# EPC DPW Stormwater\_2026-06-10\_008 - Construction Documents.pdf Markup Summary

Bret Dilts - DPW Engineering (18)

## EPC Stormwater- Zachary (12)

Laura Besler (16)

G-9
OF
14

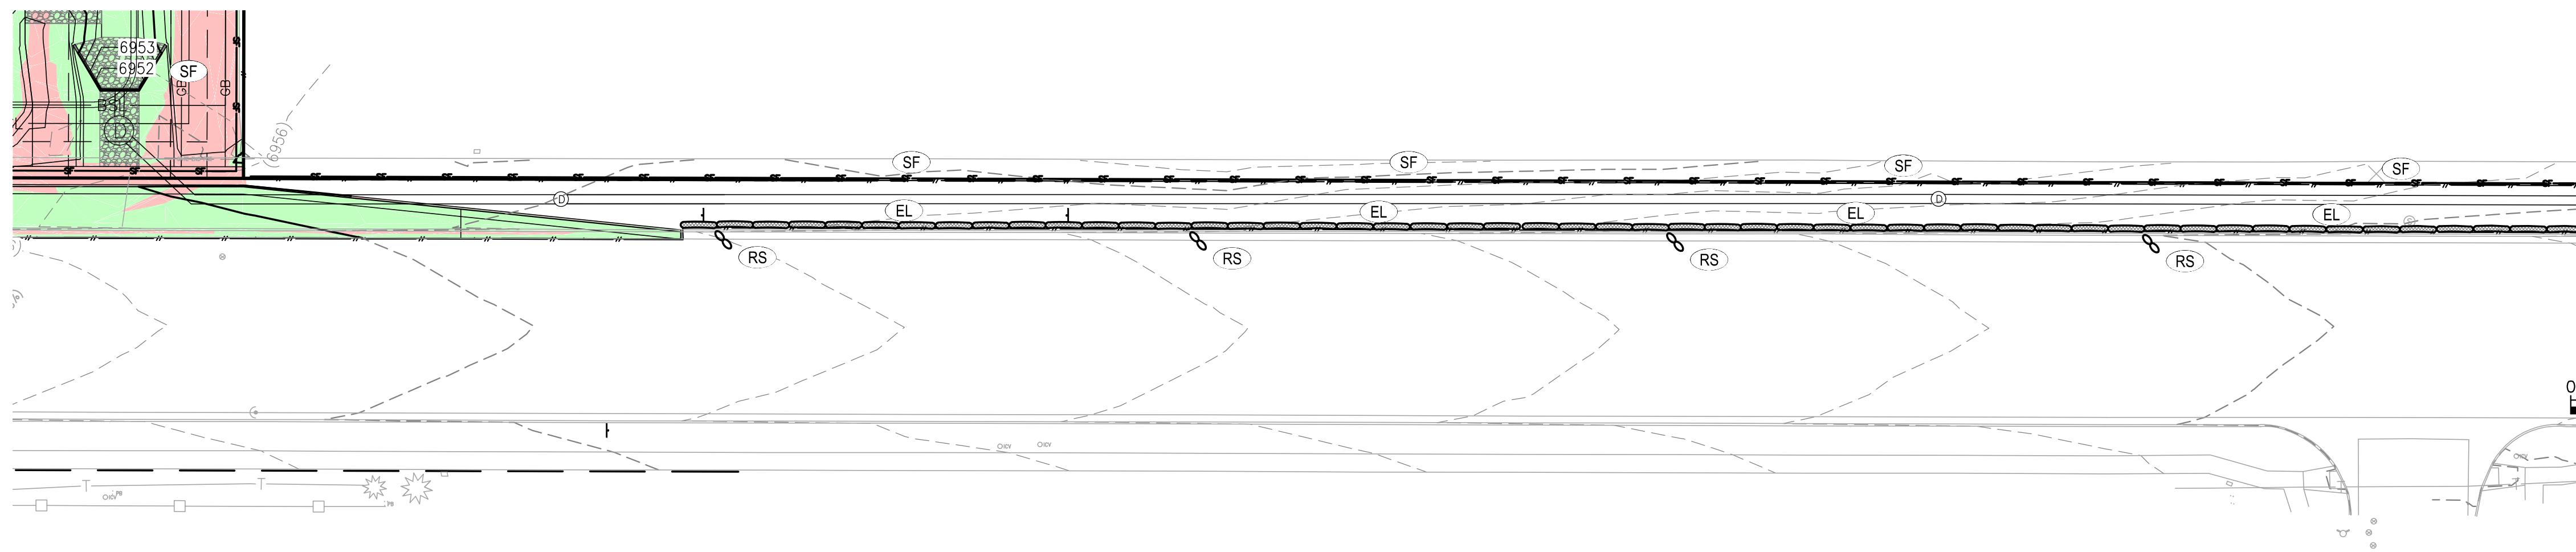
please choose one or the other on the site entrance

**RESPONSE: UPDATED TO SHOW WEST ACCESS AS MAIN CONSTRUCTION ENTRANCE**
